DRB Application No.: 02—01859 (P&F)	Project # 1002039
Project Name: ORIG. TOWNSITE OF WESTLAND	EPC Application No.:
Agent: Surveys Southwest Ltd.	Phone No.:

DRB-1002039

Subject: **Original Townsite of Westland**

REF: LOT 1-A, BLOCK 12, ORIGINAL TOWNSITE OF WESTLAND

PLAT OF  
 LOT 1-A, BLOCK 12  
 ORIGINAL TOWNSITE OF WESTLAND  
 IN PROJECTED SECTION 21, T. 10 N., R. 2 E., N.M.P.M.  
 TOWN OF ATRISCO GRANT  
 CITY OF ALBUQUERQUE  
 BERNALILLO COUNTY, NEW MEXICO  
 NOVEMBER 2002

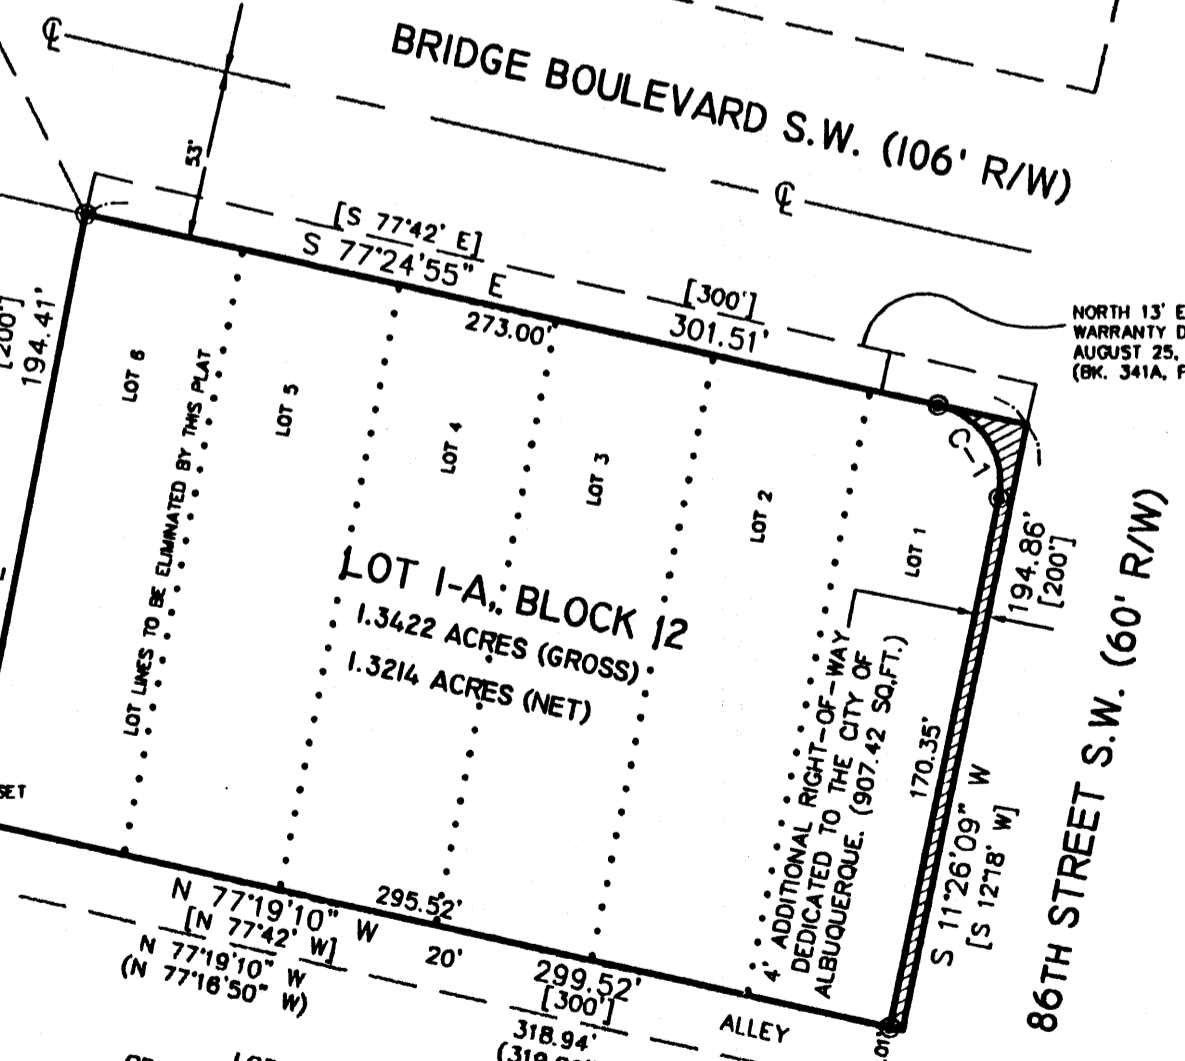
No.	Comment
<input type="checkbox"/>	The standard street improvements are required on an infrastructure list.
<input type="checkbox"/>	The streets need to meet the requirements of the DPM.
<input type="checkbox"/>	Why the two plats?

Is alley paved? If not, SIA required.

signal I.L.
